Application No.: 21/03522/OUT

Location: Os Parcel 3673 Adjoining And West Of 161, Rutten Lane, Yarnton, OX5 1LT, , Cross Parish Boundary Application: Begbroke and Yarnton Parish Councils

Proposal: The erection of up to 540 dwellings (Class C3), up to 9,000sqm GEA of elderly/extra care residential floorspace (Class C2), a Community Home Work Hub (up to 200sqm)(Class E), alongside the creation of two locally equipped areas for play, one NEAP, up to 1.8 hectares of playing pitches and amenity space for the William Fletcher Primary School, two vehicular access points, green infrastructure, areas of public open space, two community woodland areas, a local nature reserve, footpaths, tree planting, restoration of historic hedgerow, and associated works.

Thank you for forwarding the technical note prepared by the applicant in response to our 2nd response to the above application dated 23rd January 2023. We have the following comments. As a wildlife conservation charity, our comments relate specifically to the protection and enhancement of the local ecology on and around the application site.

FIGURE 15 - ACCESSIBLE MEADOWLAND

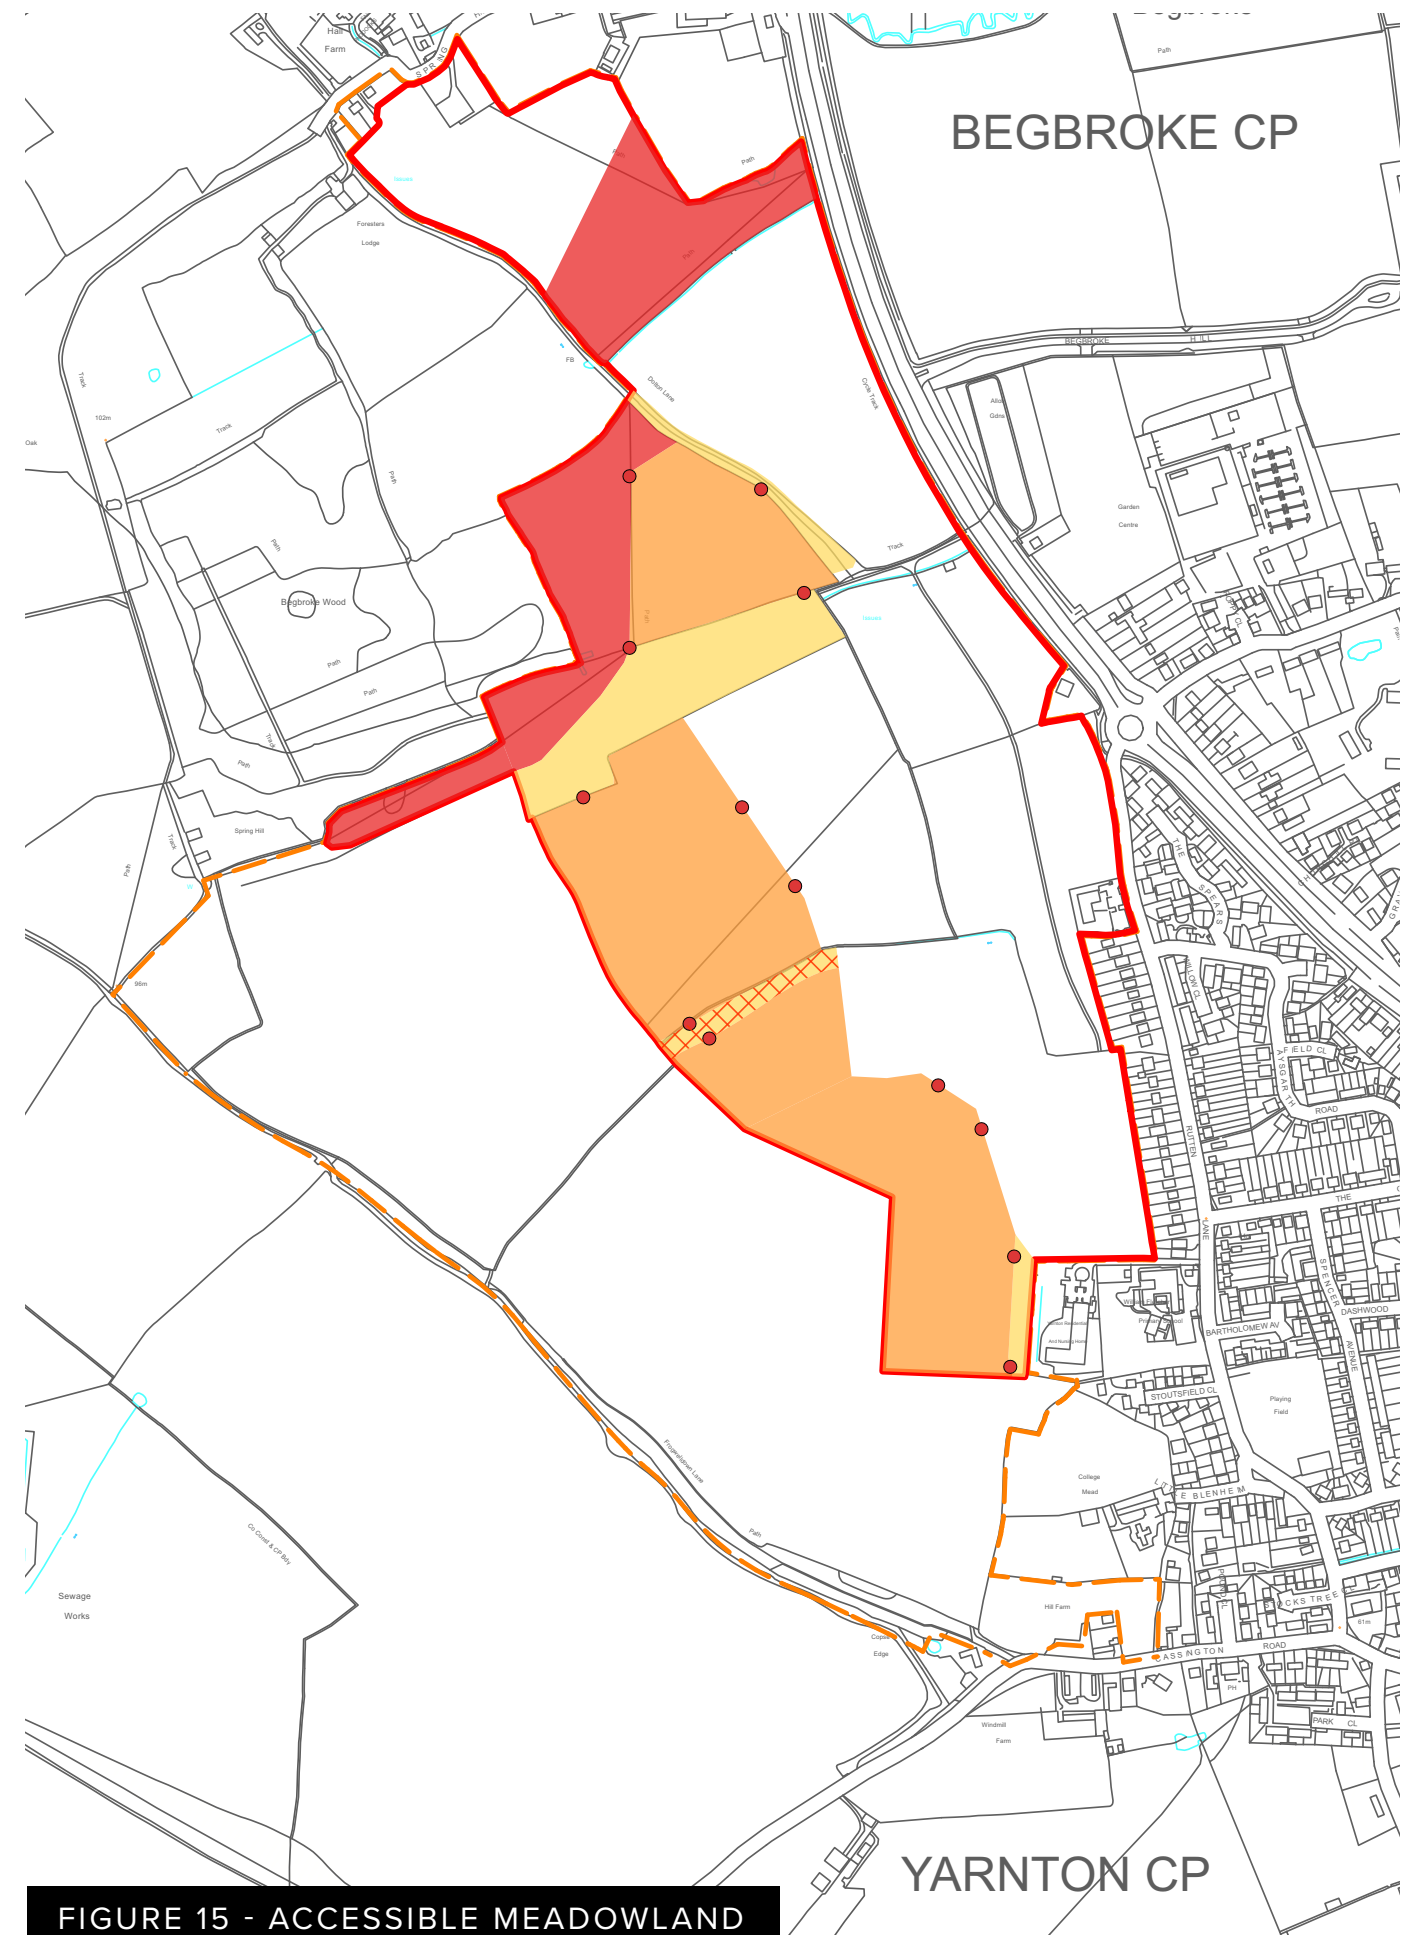
We are also concerned that the BIMP does not clearly set out the extent of public access to the meadowland and how this will allow undisturbed areas for ground nesting birds which will be necessary in order to adequately mitigate for the loss of habitat for farmland birds.
